RIBBLE VALLEY BOROUGH COUNCIL
Development Department
Council Offices, Church Walk, Clitheroe, Lancashire, BB7 2RA

TOWN AND COUNTRY PLANNING (GENERAL PERMITTED DEVELOPMENT) ORDER 2015 PART 6
PRIOR NOTIFICATION OF AGRICULTURAL AND FORESTRY BUILDINGS AND ROADS

Proposal: Prior approval for cattle building (39.55m long, 3.98m height to eaves, 35m width, 5.94m height to ridge) with covered muck midden and silo including provision of new access road and yard.

Location: Brook House, Hole House Lane, Slaidburn BB7 4TS.

Gross Area = 1090m<sup>2</sup>  
Floor plan  
1 : 100  
0 1 2 3 4 5m

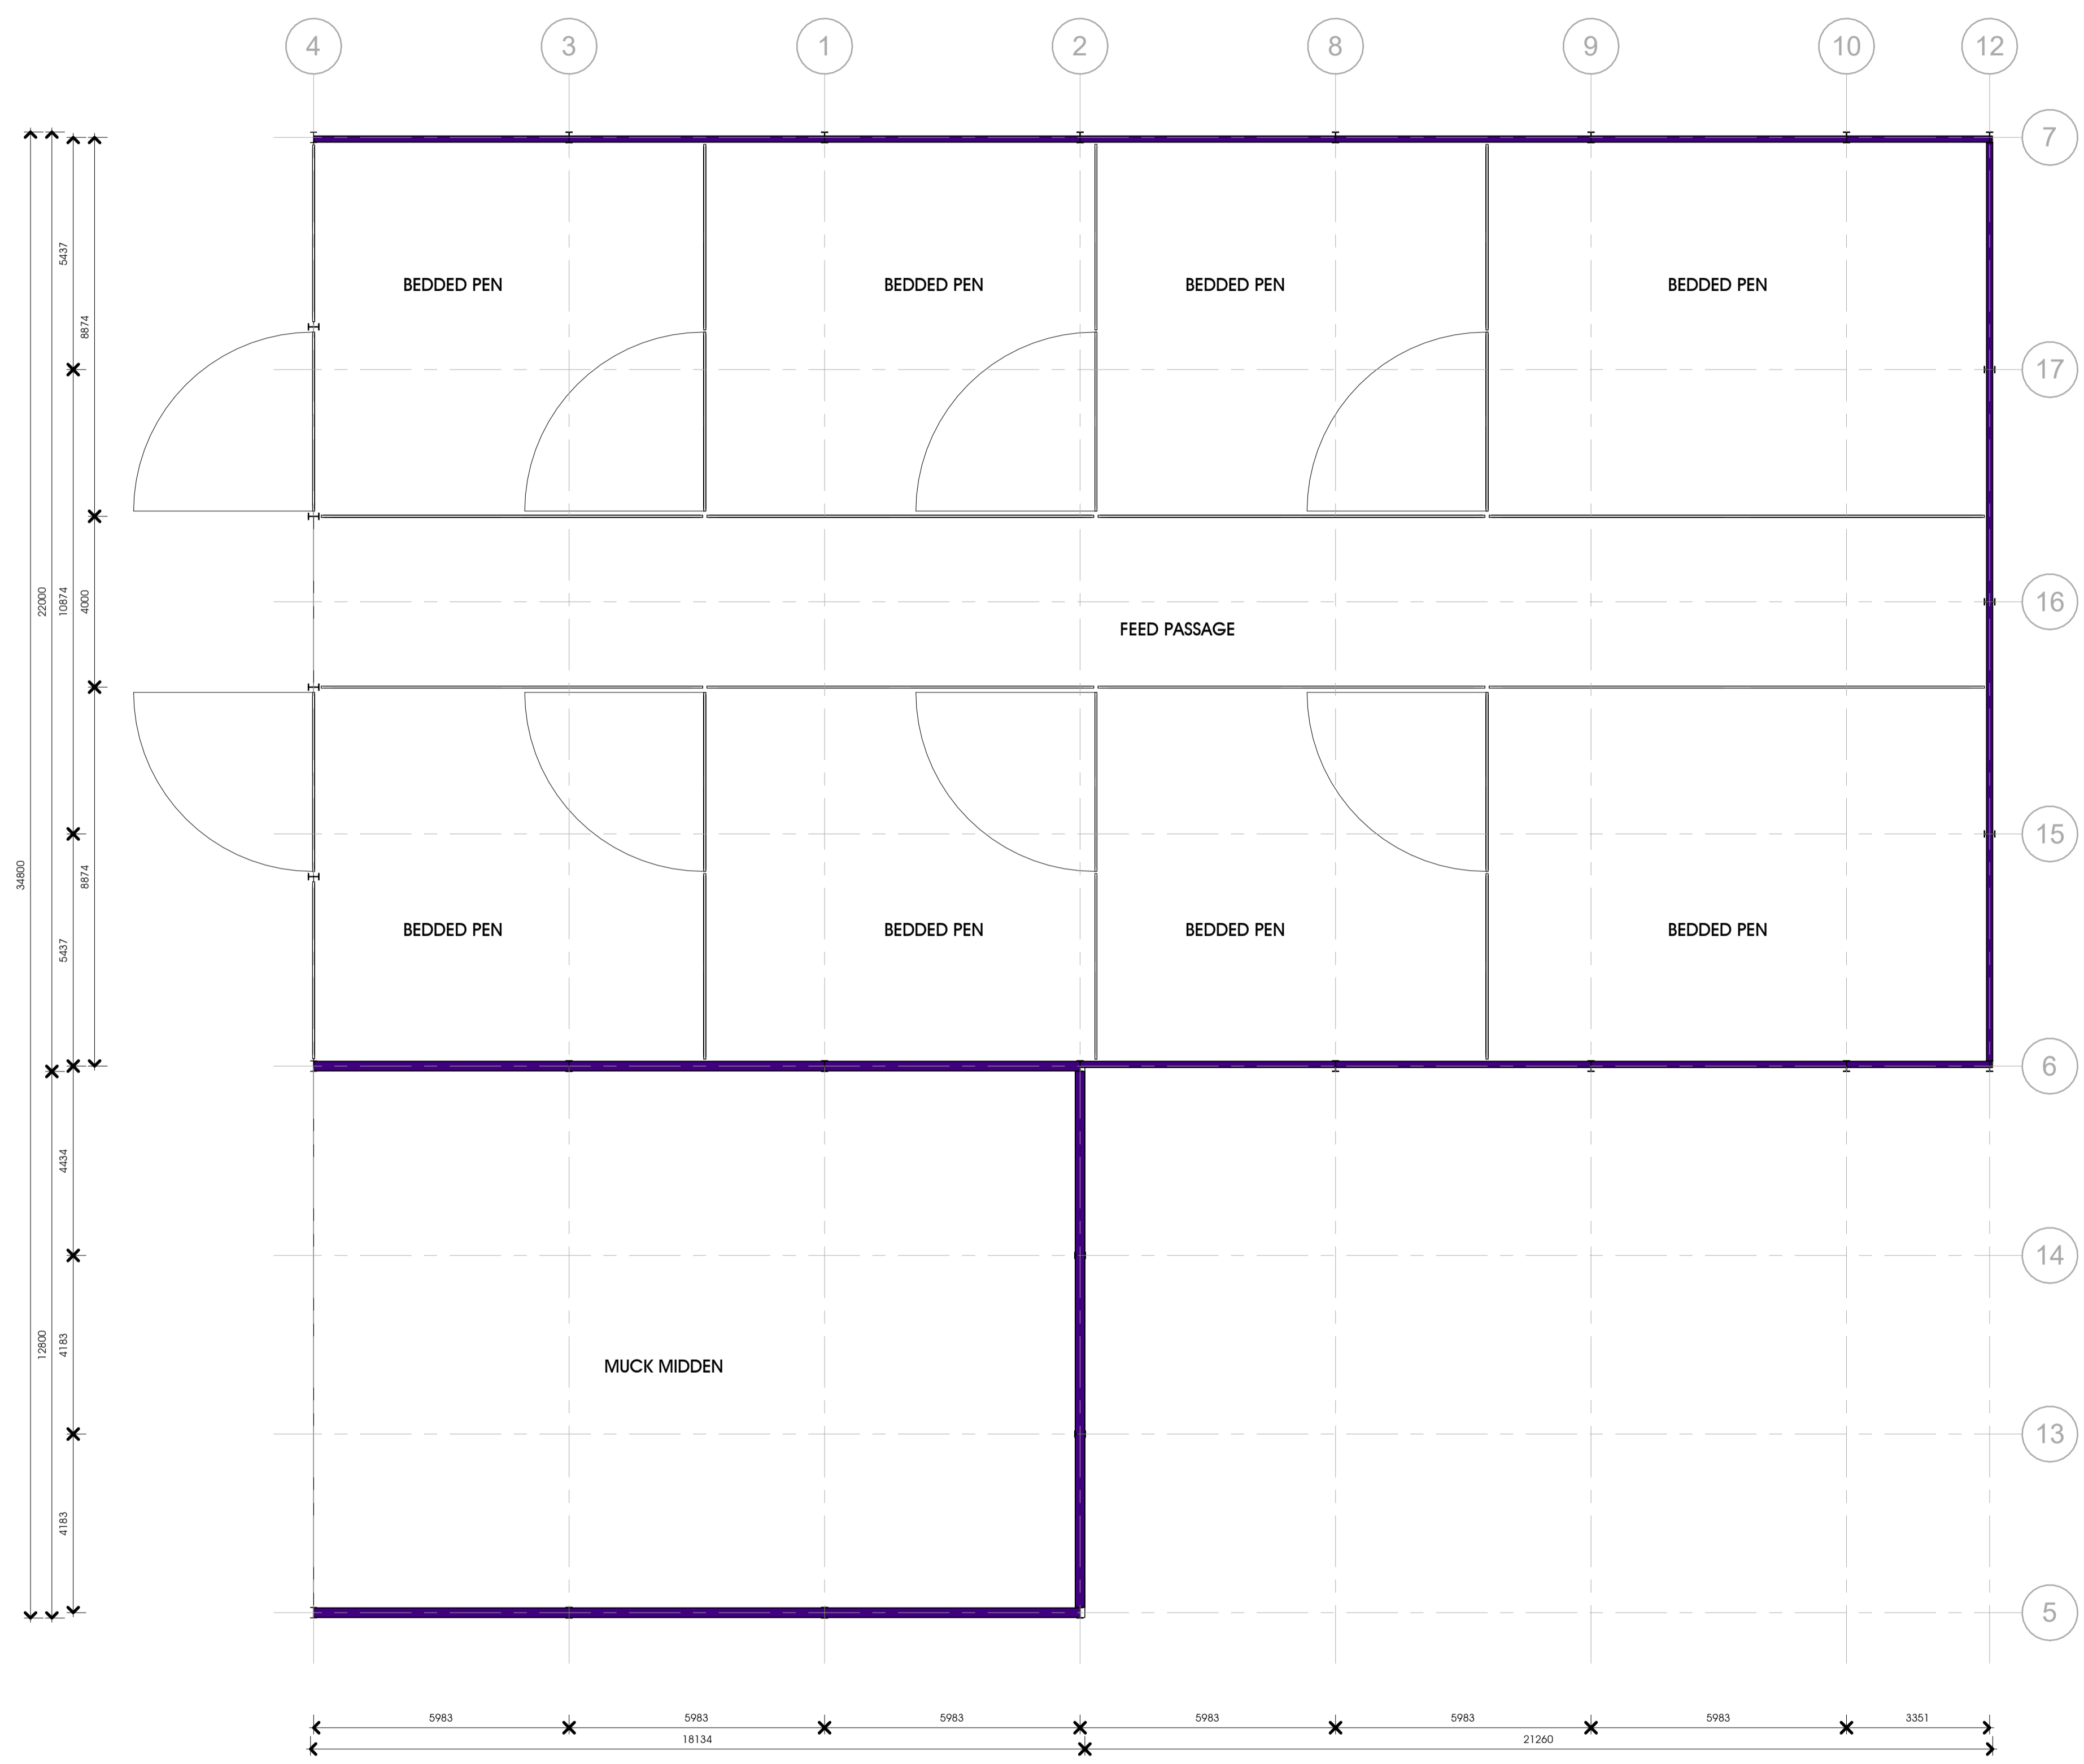
1. The proposed building exceeds 1000 square metres and therefore does not comply with criteria (e)(ii) of Schedule 2 Part 6 Class A of the GPDO given the building is designed for the purposes of housing livestock.
2. Insufficient information has been provided to demonstrate that the proposed dual access track is reasonably necessary for the purposes of agriculture in this instance.
